Sheringham Shoal and Dudgeon Offshore Wind Farm Extension Projects

The Applicant's Comments on Perenco's Deadline 6 Submission

Document Reference: 21.17

**Figure 3.1 Proximity of Dudgeon Wind Farm Turbines to the Waveney Platform**

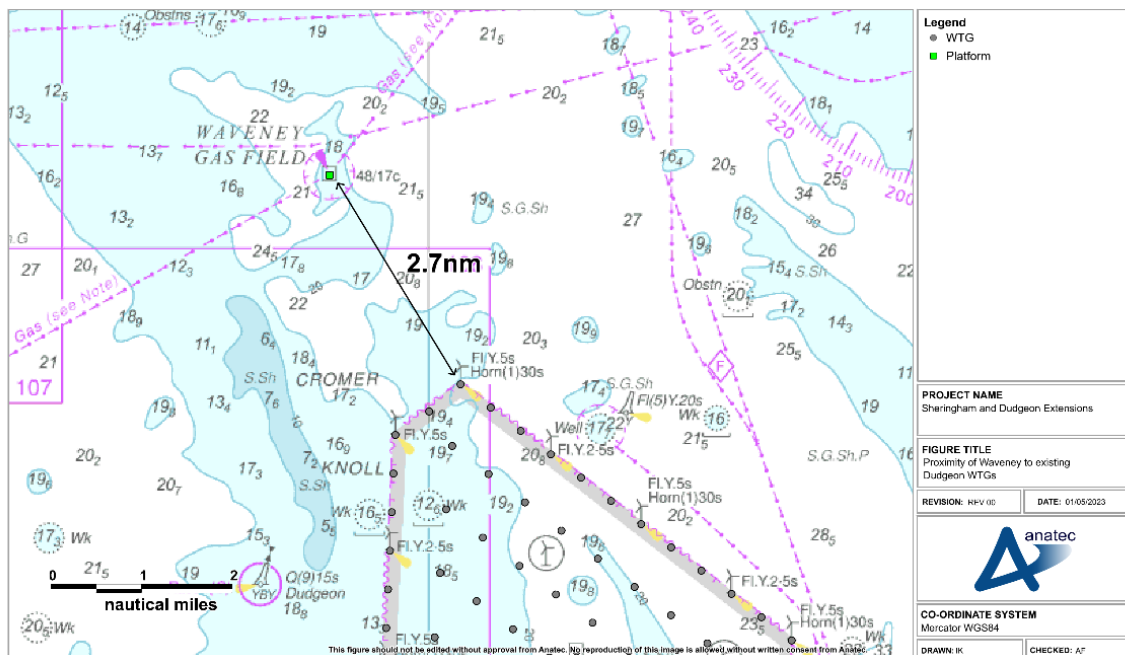
Paragraph 38	The existing Dudgeon wind farm has wind turbines within 3nm of Waveney. If the CAA implements their draft regulations in full, then all future flights to any helideck located over Waveney will be day VMC only (including any NPI operations). In this case DEP will have no additional impact on night operations, as they will already be forbidden. The CAA may issue a helicopter operator with a dispensation from the regulations, when supported by a safety case. If a dispensation is provided, then some limited night operations to a helideck at the Waveney site may be possible.	Accepted	Given that there is only a single wind turbine within 3nm and it is nearly 3nm away, it is highly likely that the CAA would grant a dispensation such that the anticipated new rules concerning flights within 3nm of a windfarm would not preclude night flying to Waveney, other than within the existing limitations of night flights.	Noted. However, there are three turbines within 3nm of Waveney currently operational at the existing Dudgeon Offshore Wind Farm. The closest of these three turbines is 2.7nm.
